6 December 2021

Thank you giving Ku-ring-gai Council the opportunity to provide a submission for Application No. SSD-17424905 (Pymble Ladies Collage – Grey house Precinct) at 20 Avon Road, Pymble. Council's comments in relation to the proposal are as follows:

2 SHADOW DIAGRAM EXISTING June 21 - 1PM
1 : 1000

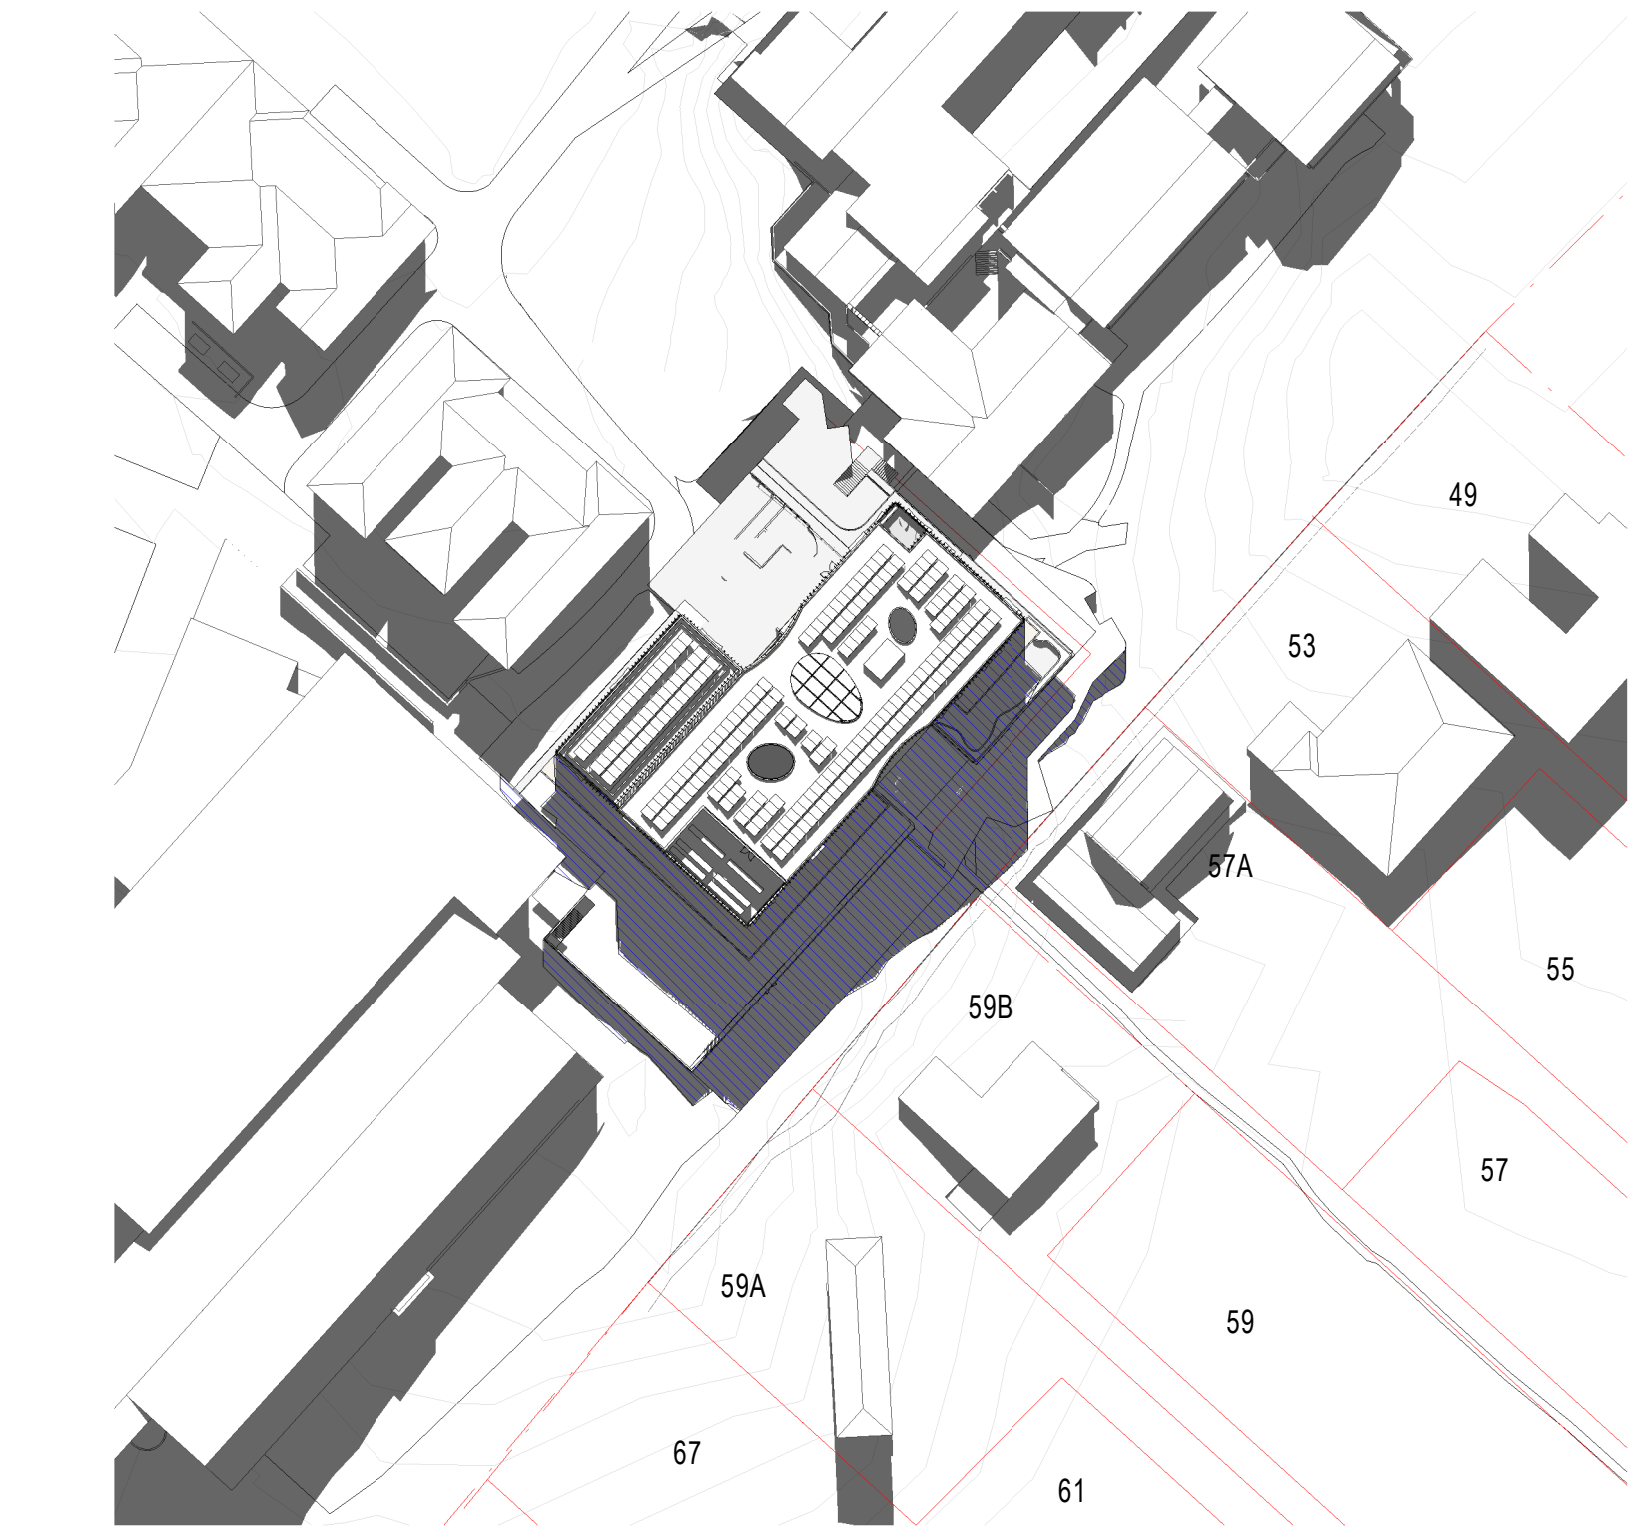
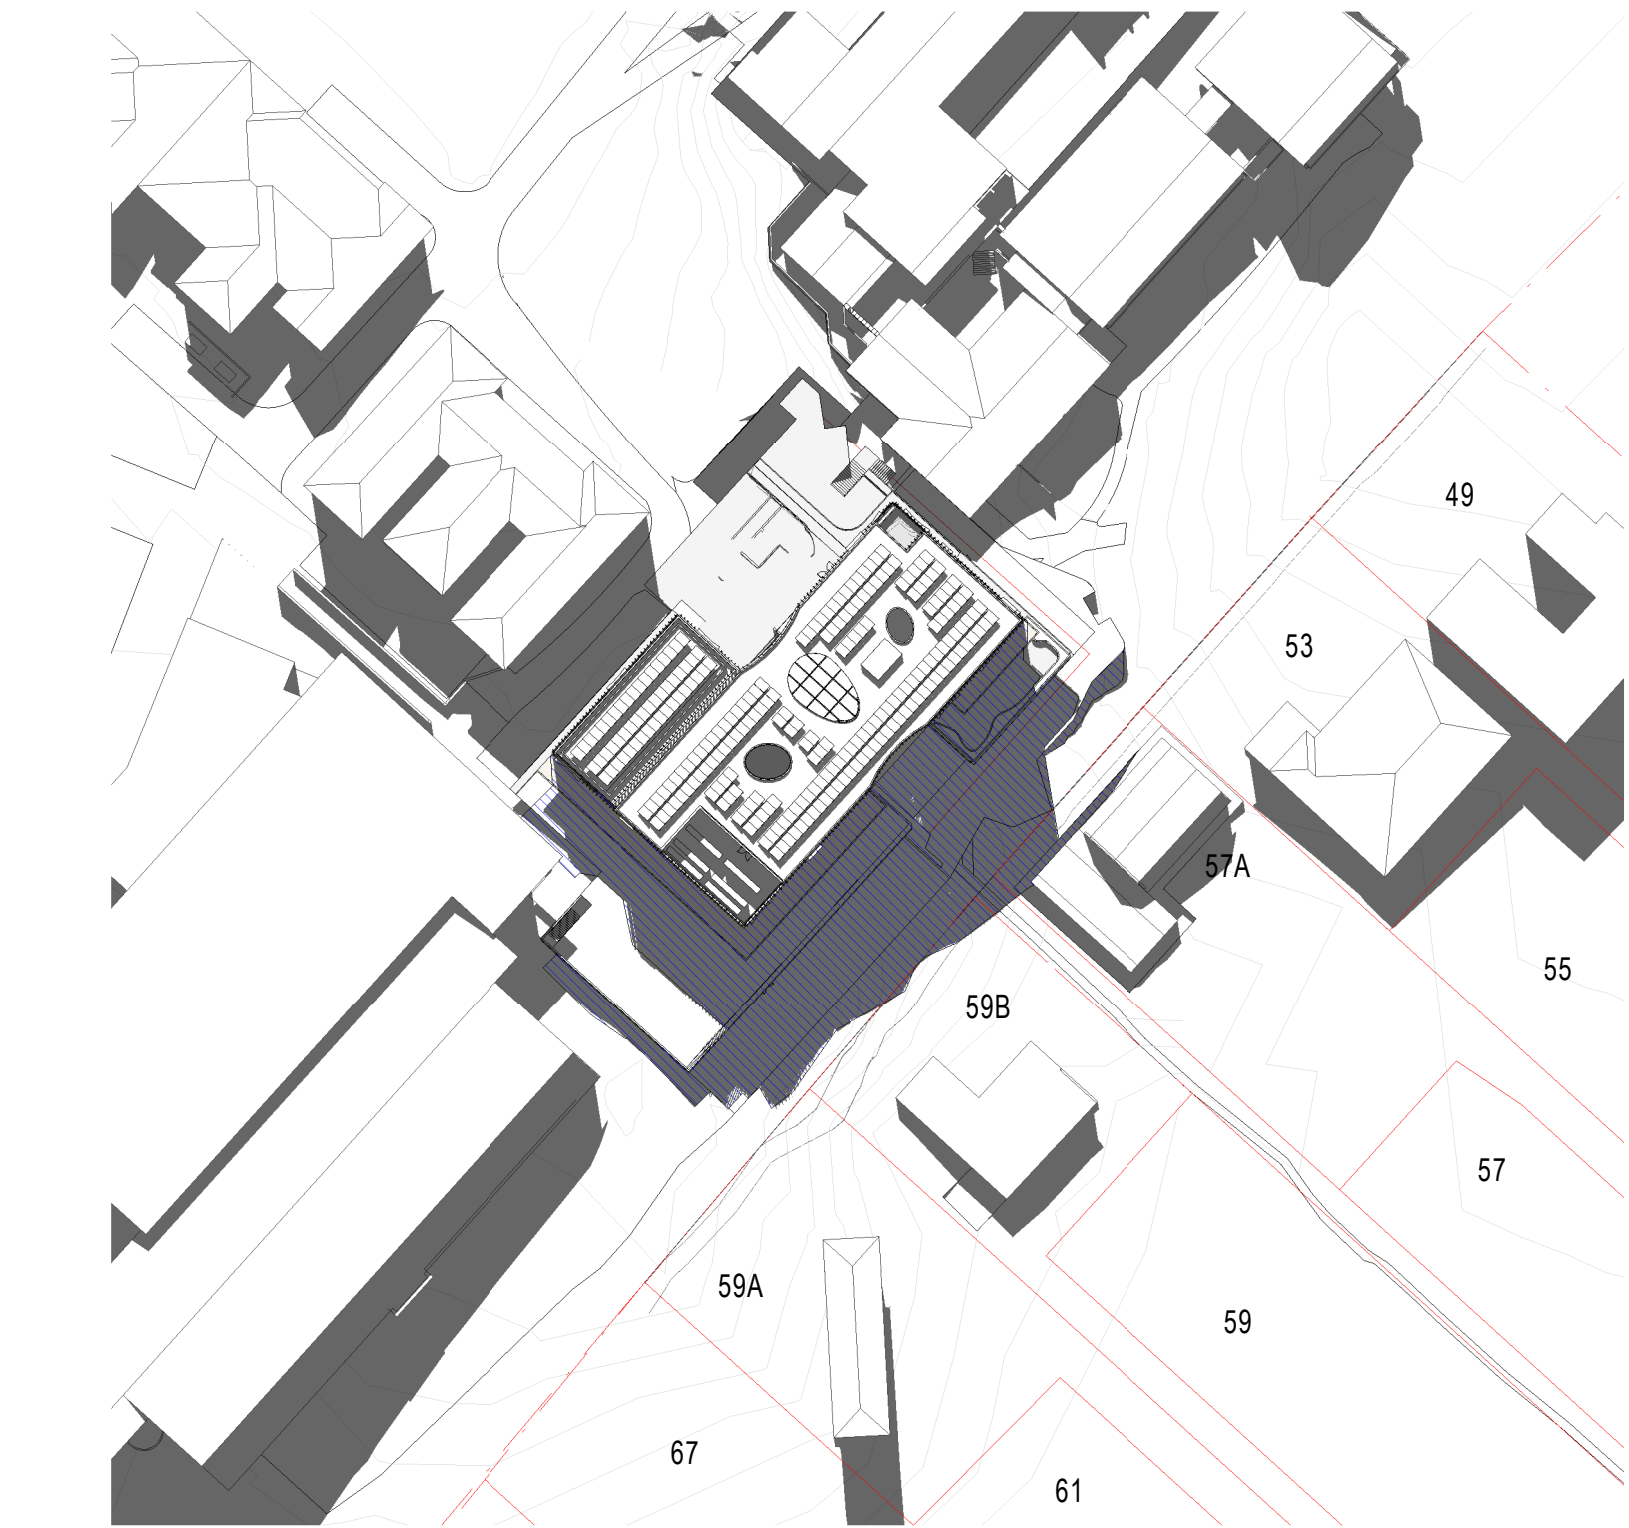
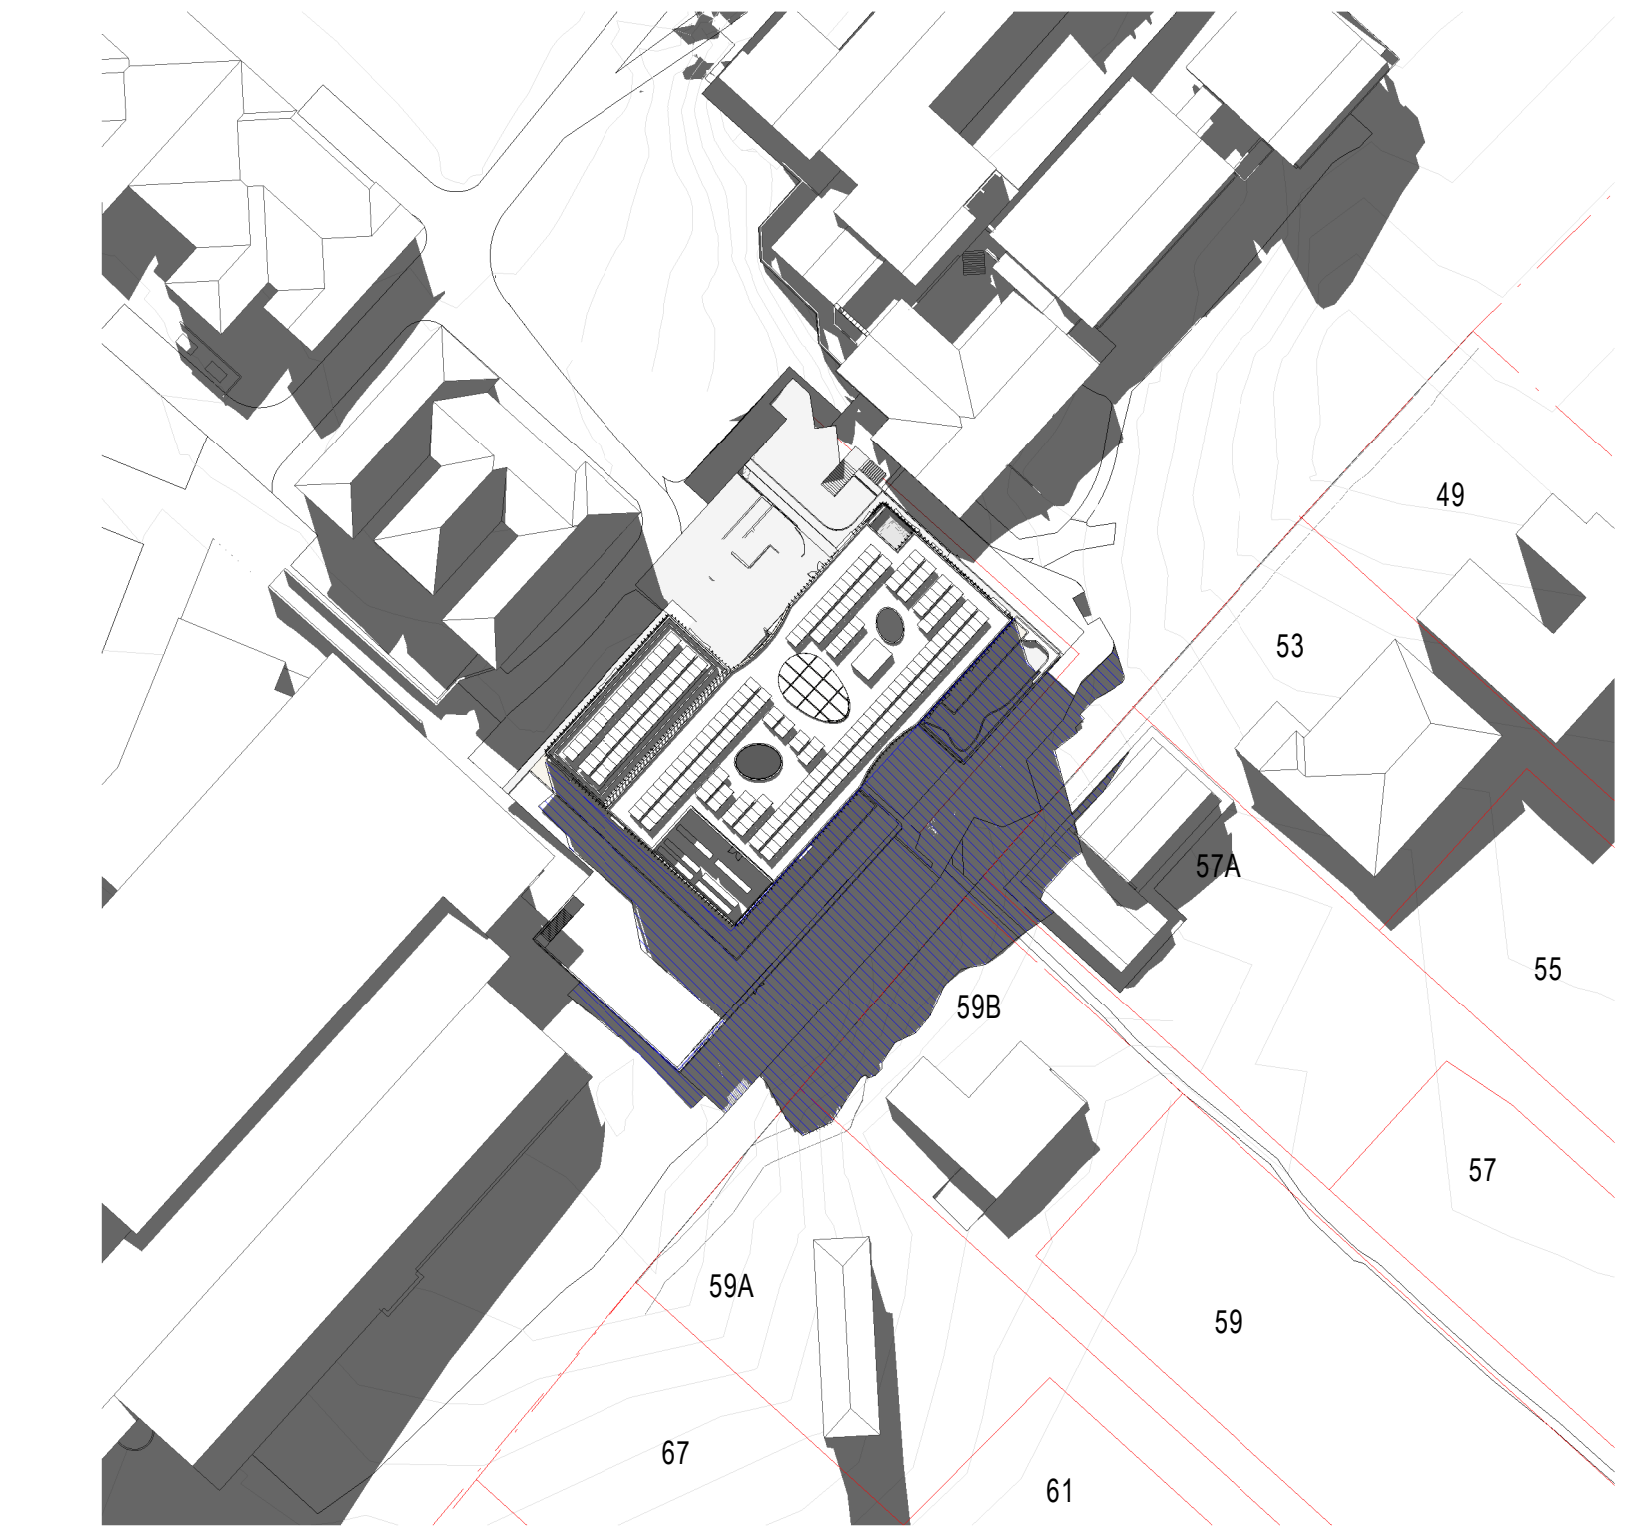
Page 85 of the EIS contains the following statement:

*As shown in the Shadow Diagrams (**Appendix 8**), no additional overshadowing of the adjoining properties would be created prior to 12pm midday on the Winter solstice. As such, the proposal would effectively maintain three (3) hours of solar access between 9am-12pm on the Winter solstice, thereby complying with KDCP.*

This statement is flawed for the following reasons:

As the proposal predominantly impacts upon windows on the rear (north-western) elevations and rear private open space of adjacent dwelling houses the impacts upon these dwelling houses cannot be properly assessed using the plan view shadow diagrams that have been provided. A more detailed analysis of overshadowing impacts is required. Having regard to the scale of the proposal and the disparity in height between the proposed building and adjacent dwelling house it would be reasonable for the applicant to adopt the requirements of the Land and Environment Court Class 1 Practice Note which are set out below:

- *be based on true north;*
- *indicate the location and nature of existing and/or proposed fencing, with the shadows projected;*
- *indicate horizontal and vertical impact, including any impact from any substantial wall;*
- *provide a table of compliance and non-compliance with known criteria (such as a development control plan, a State environmental planning policy or Australian Model Code for Residential Development (AMCORD)); and*
- *make appropriate allowance for the topography.*
